# CITY OF ALBUQUERQUE

January 16, 2013

**Re: Guardian Storage-Holly  
Grading and Drainage Plan  
Engineer's Stamp Date-no stamp- (C19/D056)**

CONCEPTUAL GRADING AND DRAINAGE PLAN GUARDIAN SELF STORAGE

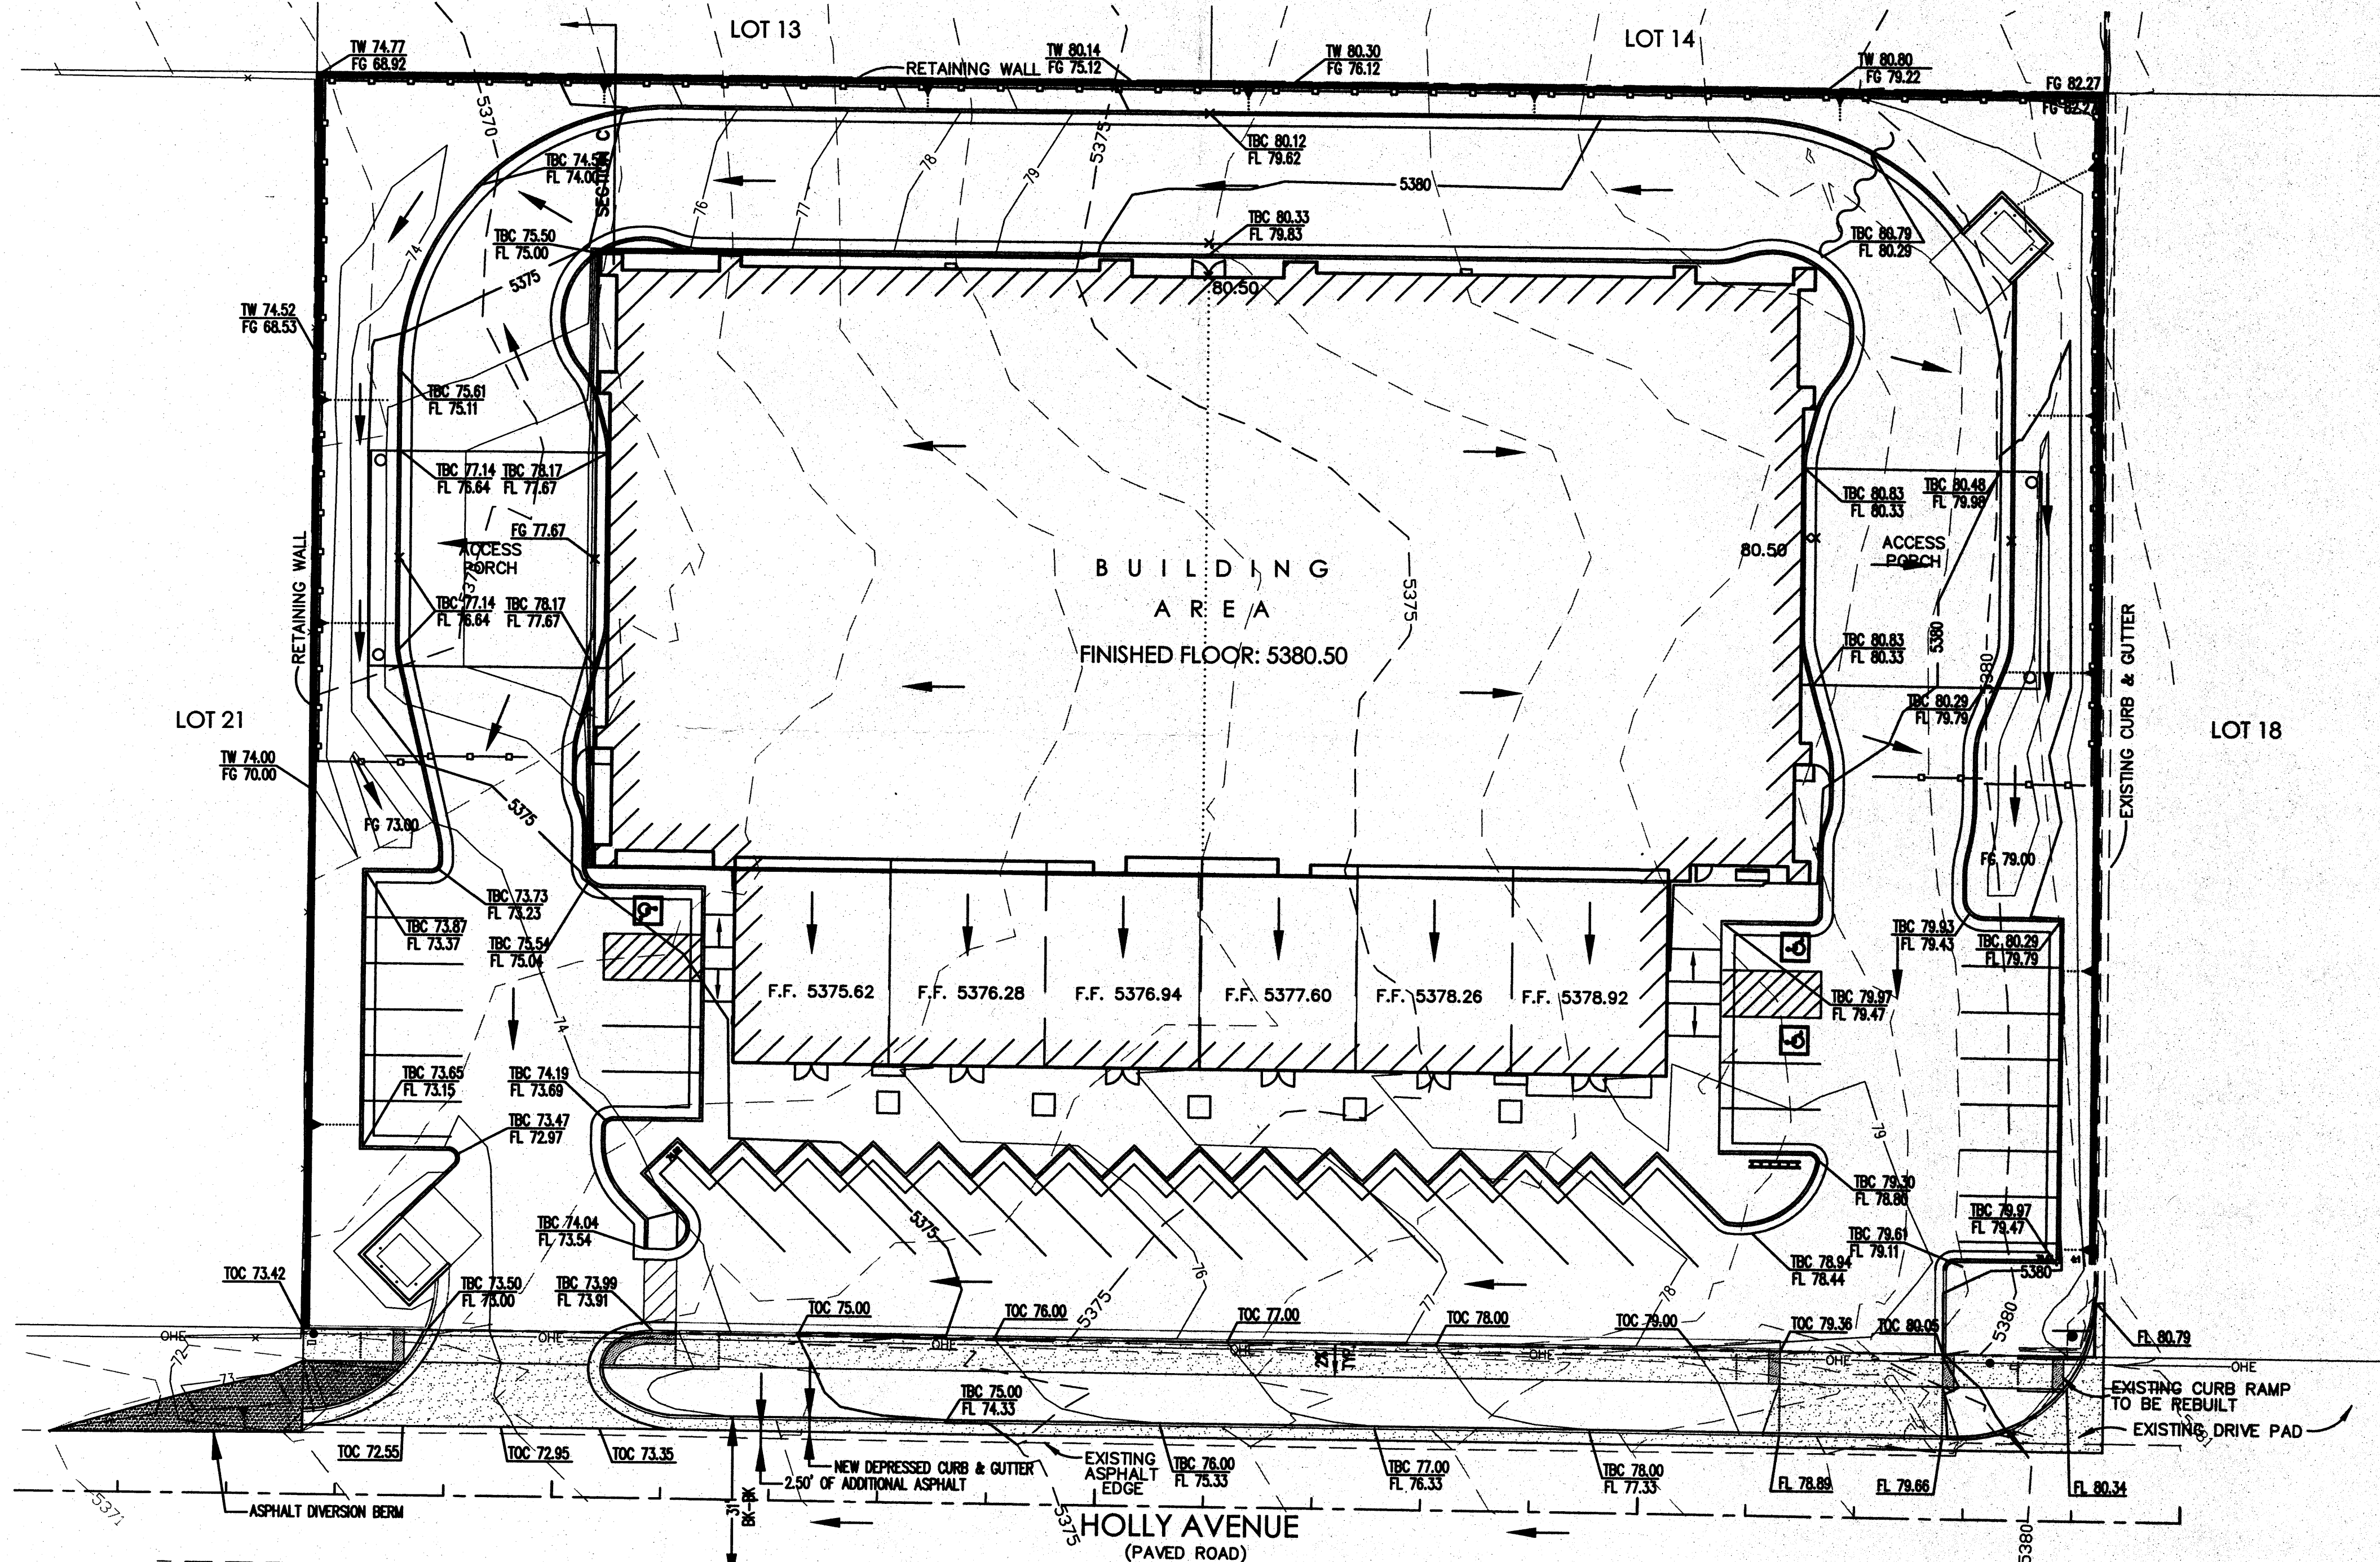
- The plans must be stamped, signed and dated by a PE.
- Show existing contours surrounding the site.
- Additional elevations should be given on sidewalks.
- Standard flow and volume calculations per the DPM are required.
- Provide a table showing existing flows and developed flows.
- Show the elevations at the dumpster sites and the inlet tying into the SAS system.
- Show a section of the retaining walls. A max height of 8' can not be exceeded unless a variance is obtained. Also if retaining more than 18" a designed drawing must be provided.

Hydrology is requesting that proposed landscape areas be depressed to retain/infiltrate the rain that falls on them. This project requires a National Pollutant Discharge Elimination System (NPDES) permit for storm water discharge. Prior to Certificate of Occupancy release, Engineer Certification per the DPM checklist will be required.
